Recommendation Report for Planning Permission for Works or Extension to a Dwelling

REF NO: BE/75/20/HH

LOCATION: 50 Mansfield Road  
Bognor Regis  
PO22 9HB

PROPOSAL: Single storey side extension.

DATE JULY 2020	DRAWN BY LF	PROJECT 50 Mansfield Road, Bognor Regis, PO22 9HB	JOB NO. 117	DRAWING TITLE Proposed Floor/Roof Plans
	CHECKED BY LF	DRAWING NO. 117 - 03	REV A STATUS Planning

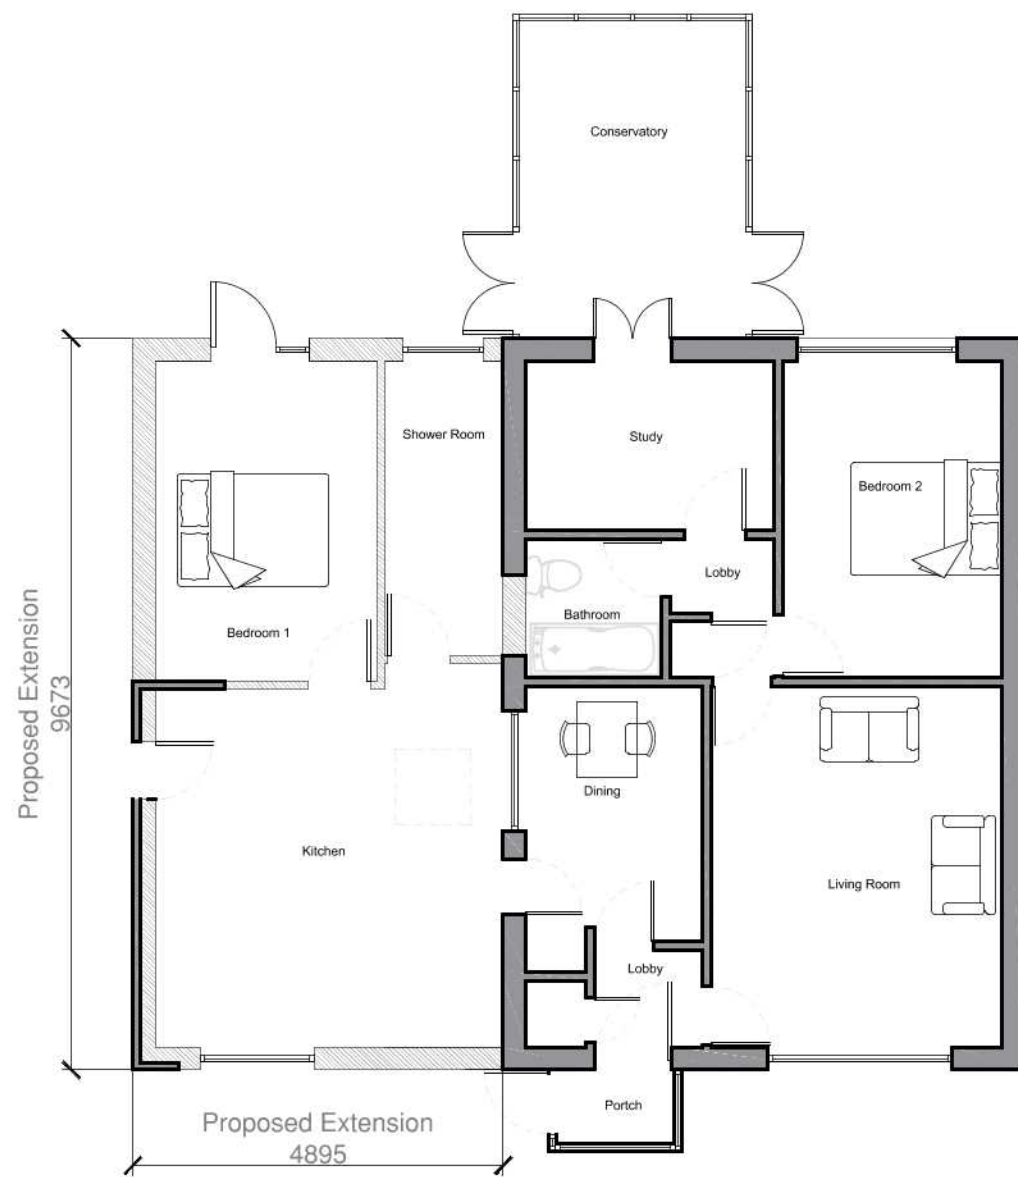
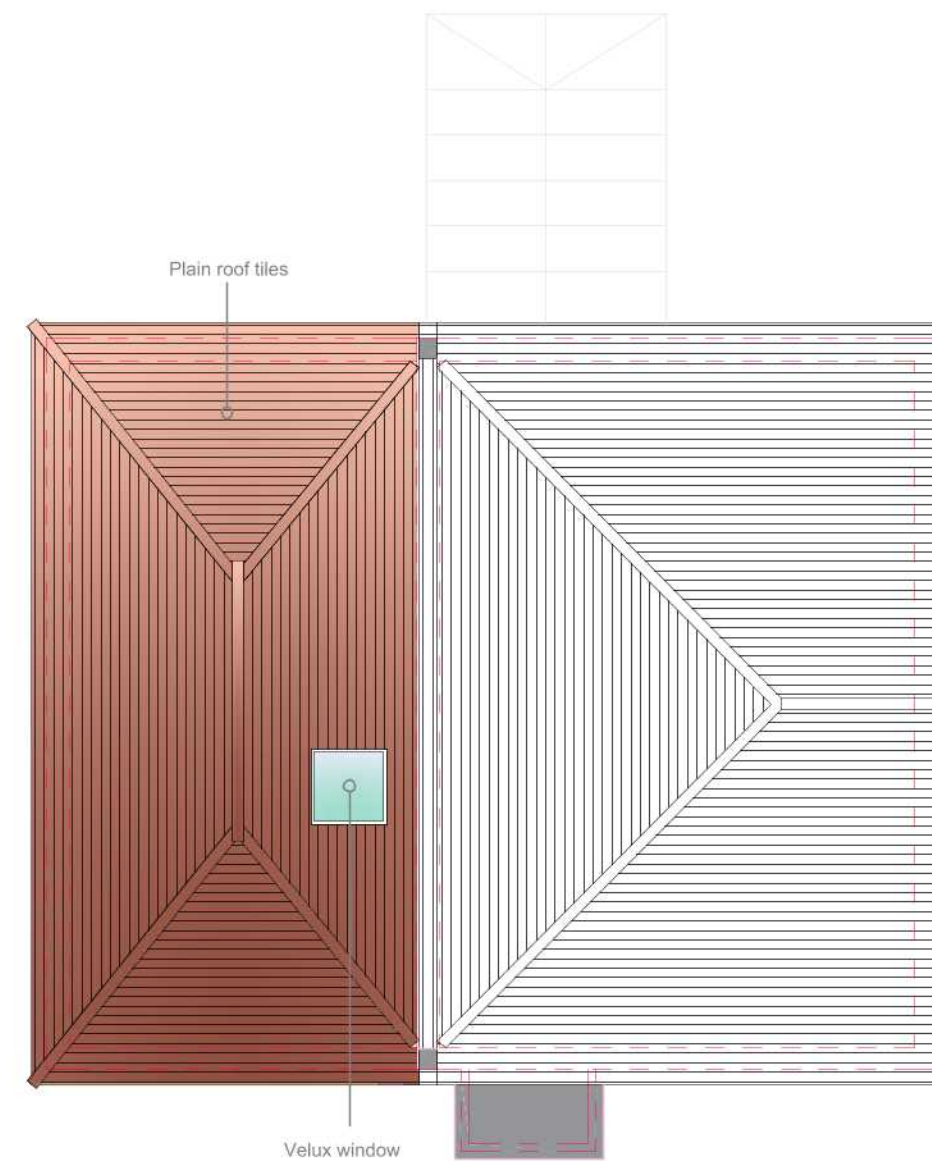
The extension would provide bedroom, shower room and a large kitchen which would be serving to the main house as well. Would be well integrated with the built form of the host dwelling and therefore the development would have no harmful impact upon the character of the host dwelling, or its locality. The application is considered to be in accordance with D DM1, D DM4(a) and (b) of the Arun Local Plan and Arun Design Guide.

DATE JULY 2020	DRAWN BY LF	PROJECT 50 Mansfield Road, Bognor Regis, PO22 9HB	JOB NO. 117	DRAWING TITLE Proposed Elevations
	CHECKED BY LF	DRAWING NO. 117 - 04	REV A	
		STATUS Planning

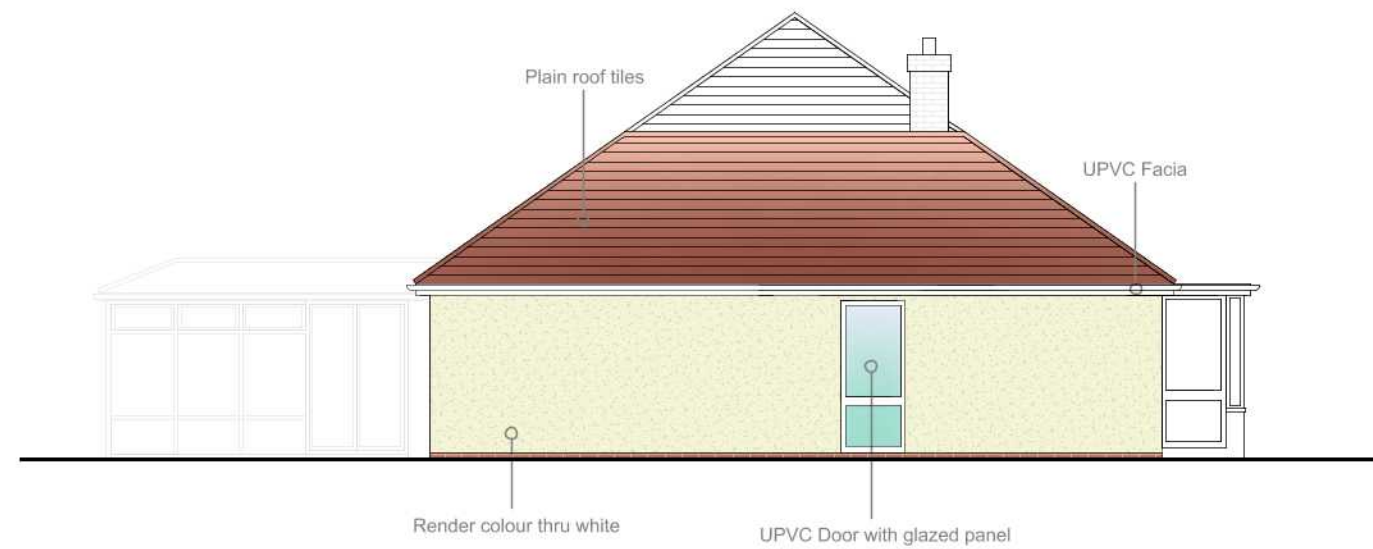
The dwelling occupies the corner position with an access to Yew Tree Close from Mansfield Road. The side extension would be entirely open to the street scene. The extension would extend the north elevation of the house, replacing a garage, and would have the same depth as the host building and has a hipped roof of the same pitch as the existing roof. One rooflight would be inserted to the roof plane facing the host building. The development is a subservient and well integrated addition to the host dwelling in terms of its scale, and use of materials. Dwellings in the locality are host to a variety of extensions and alterations which allows the proposal to not appear as an intrusive feature in the area.
